Our ref: Q200424/el/el3
Your ref: 20/02779/REM
Email: Emma.lewis@quod.com
Date: 21 September 2021

Non-Material Amendment - Catalyst Bicester

The application seeks approval for a non-material amendment (NMA) to modify Reserved Matters approval ref. 20/02779/REM.

Drawing Title.  
**UNIT 4  
FLOOR & ROOF PLANS**

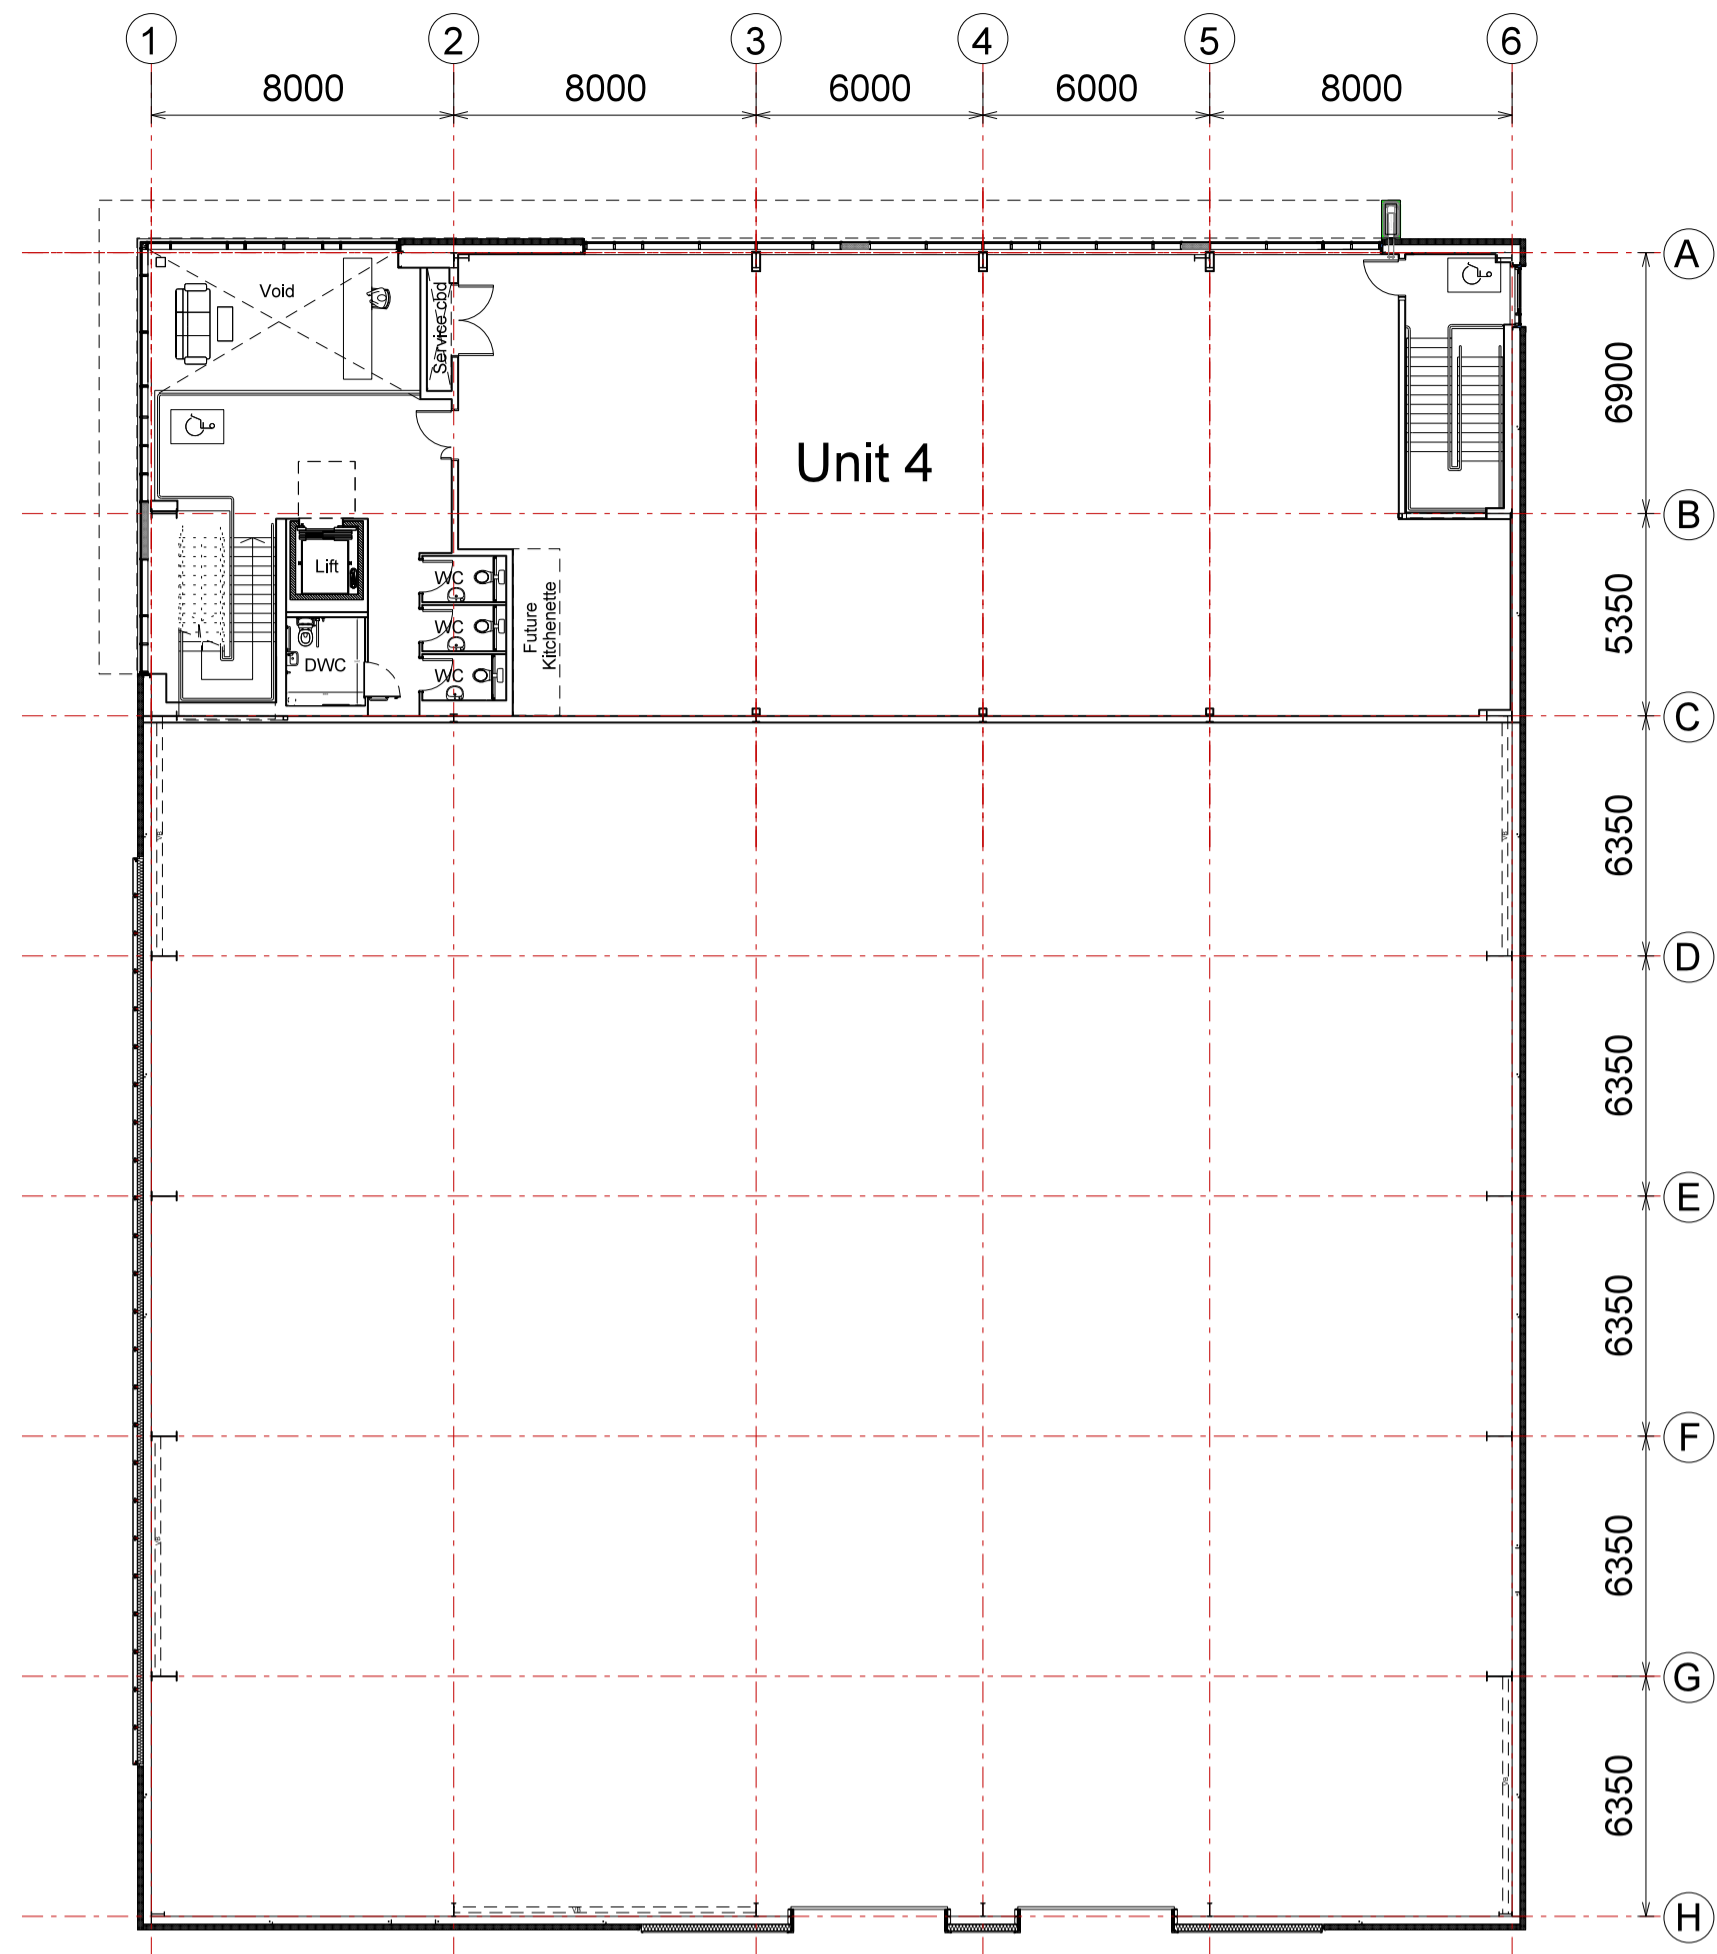
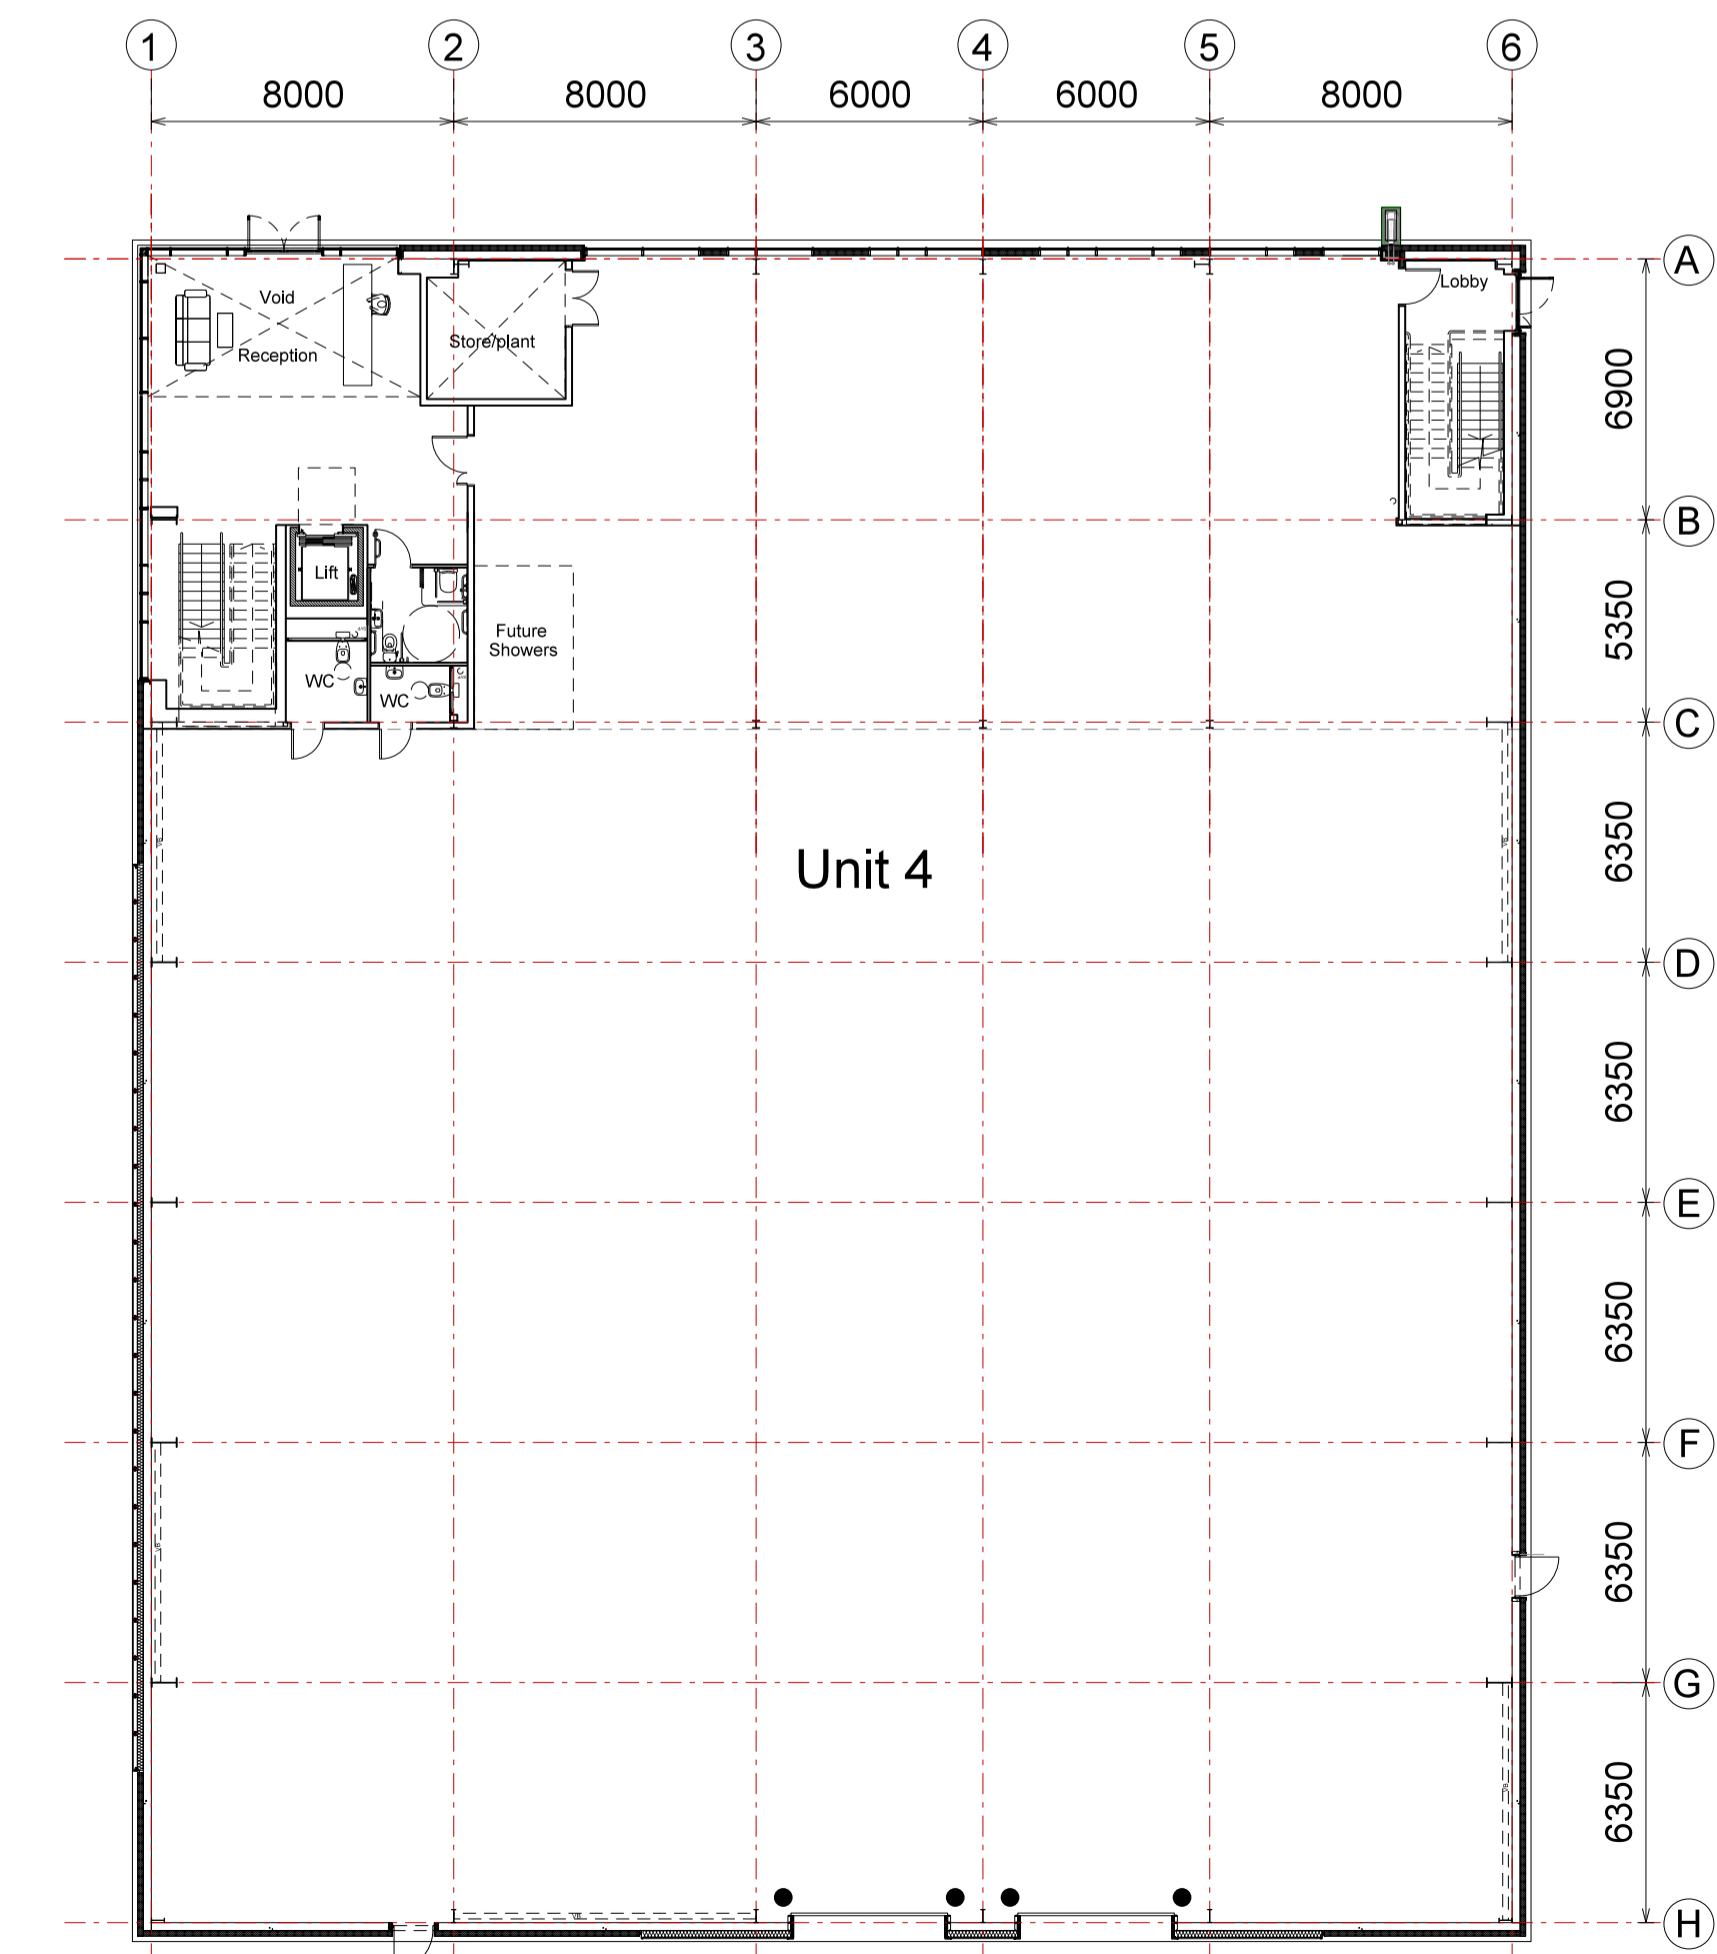
Through the installation of additional mezzanine floor space the GIA of Phase 1 will increase to 5,490sqm (an additional 364 sqm, which amounts to an increase of just 7%), and therefore will not conflict with Condition 24 of 19/01740/HYBRID which states that “*The development hereby permitted shall comprise a maximum floorspace of 16,800sqm...*”.

Further, whilst the mezzanine floorspace is intended to be used for office uses ancillary to the main operation of the units, the quantum of office uses will still sit comfortably under the 5,880 sqm permitted by the outline planning permission (also set out at Condition 24). The total mezzanine floorspace across the whole of Phase 1 is 1,527 sqm.
